## Memo

**From:** Holly Myers, Environmental Health Supervisor

**RE:** BL-15-000017 Whitaker

CRUSE & ASSOCIATES
PROFESSIONAL LAND SURVEYORS
217 East Fourth Street P.O. Box 959
Ellensburg, WA 98926 (509) 962-8242
WHITAKER PROPERTY

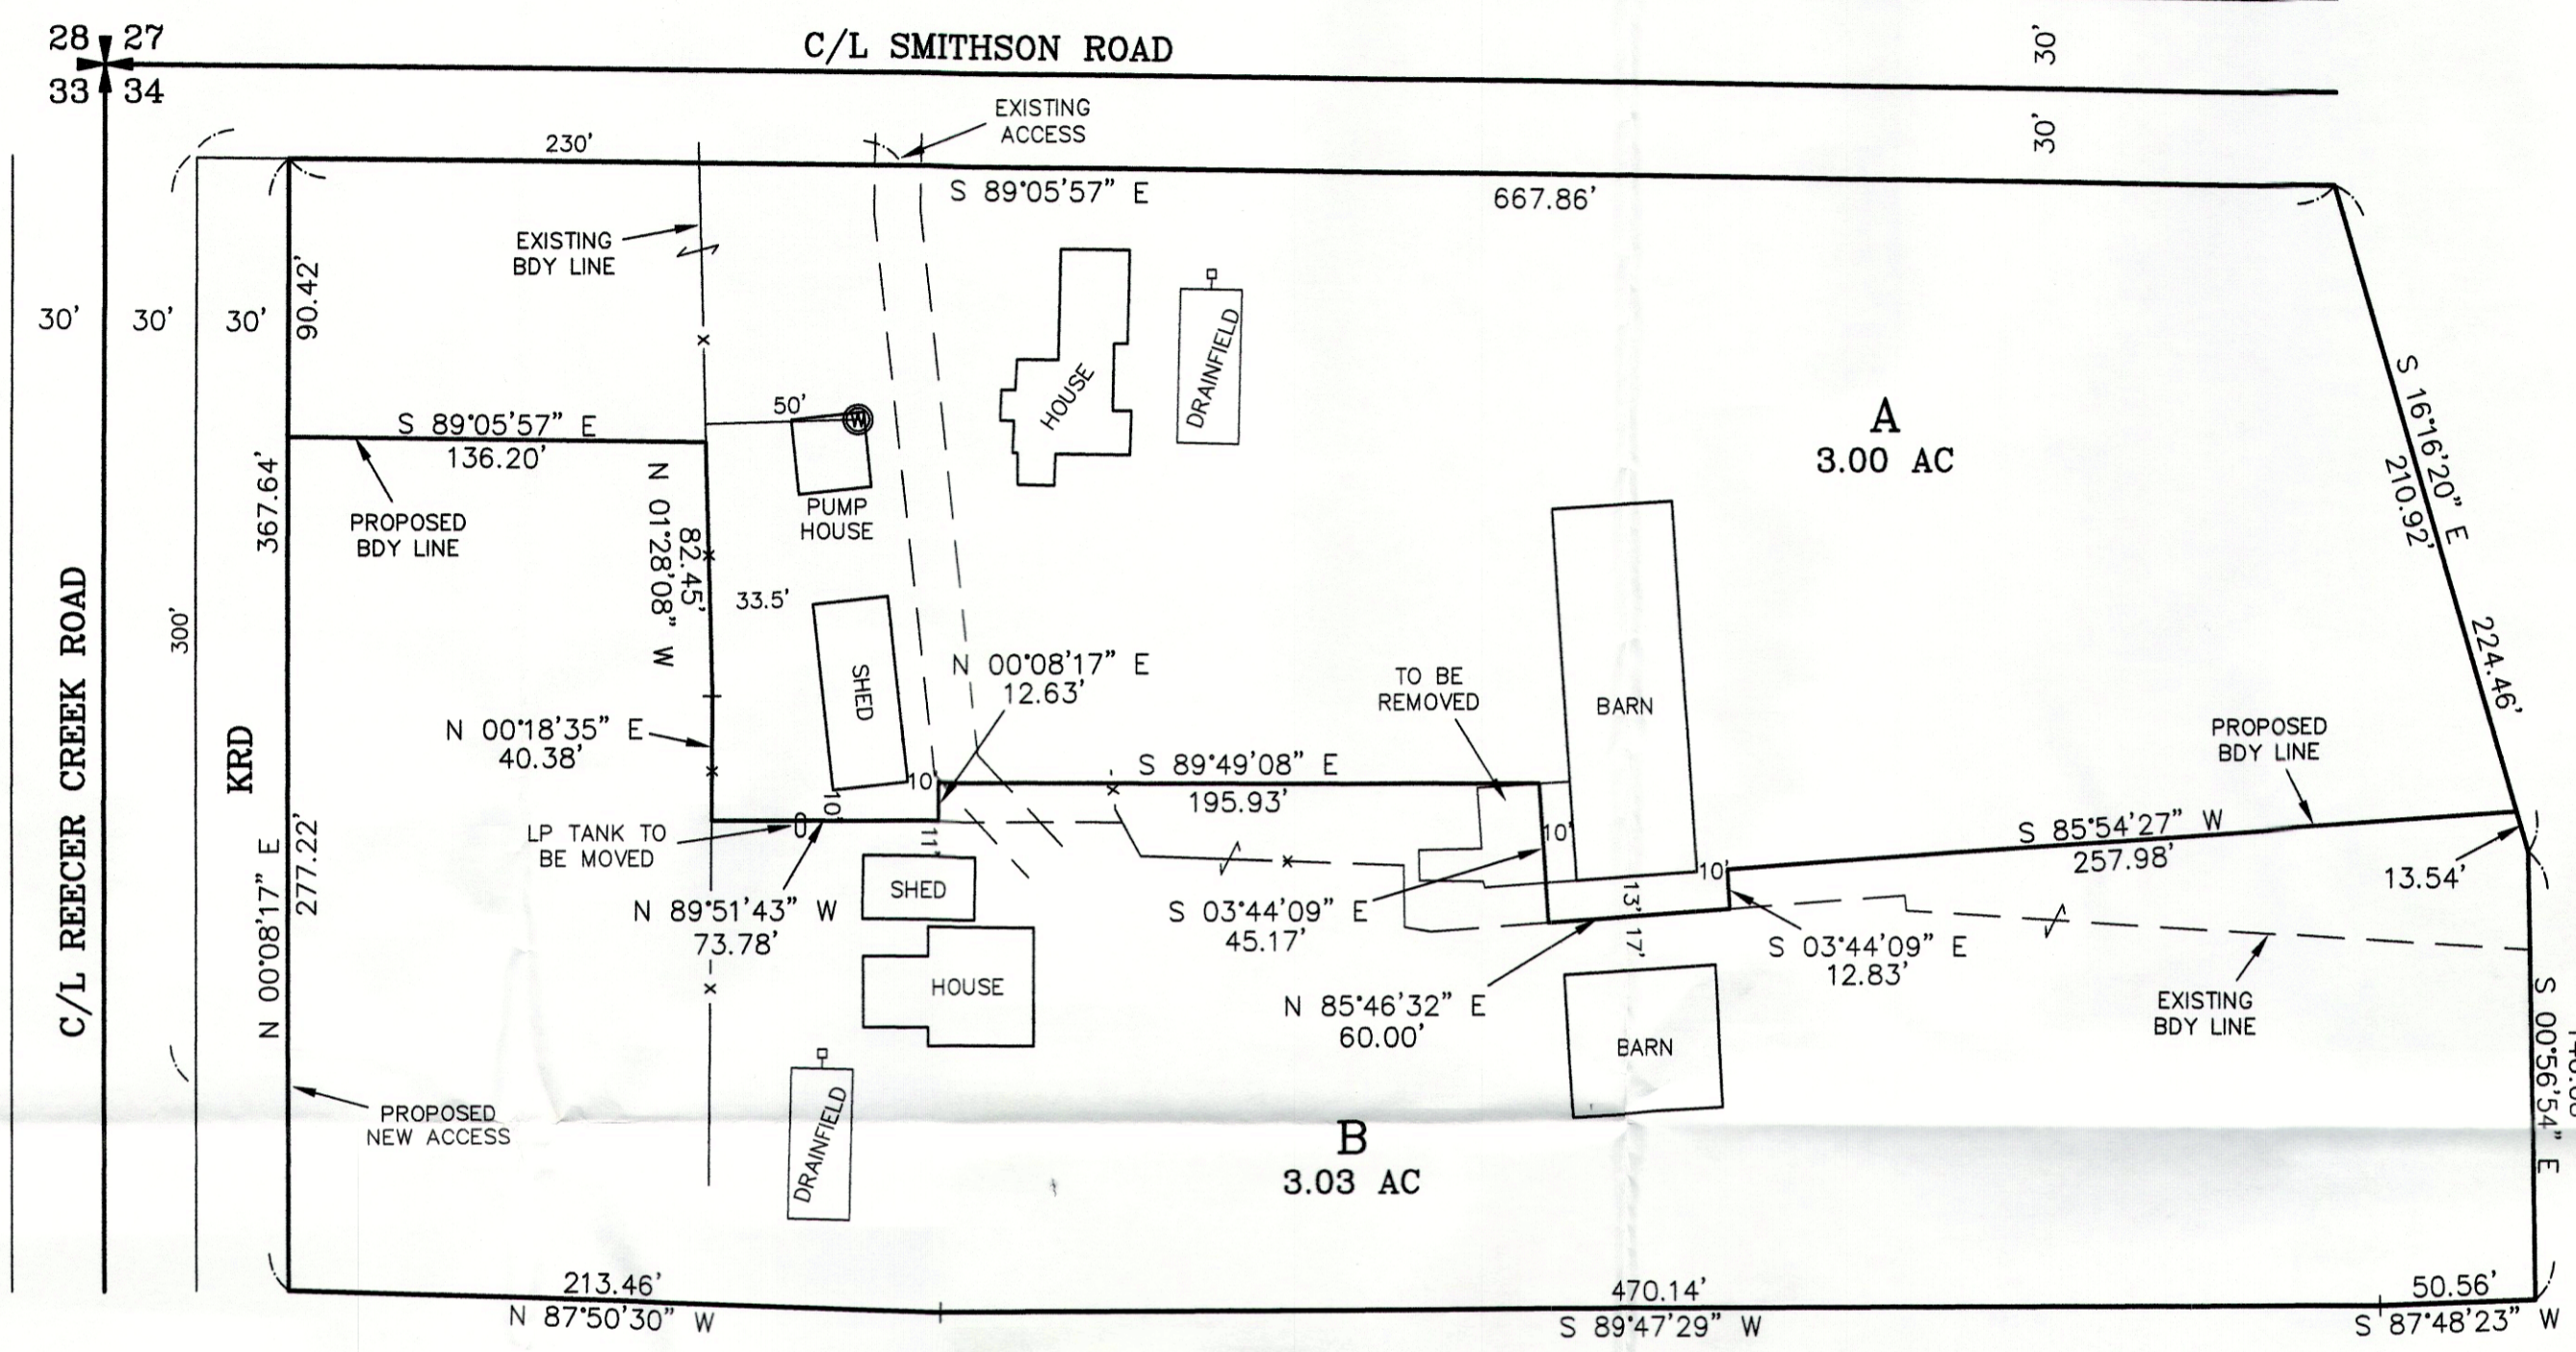
After reviewing this application the setback measurements for the well on the north parcel are evident but the location of the well on the south parcel is not marked on the maps. In order for final approval of this application, Public Health requires a site plan be submitted showing the location and setback measurements of the well on the south parcel.
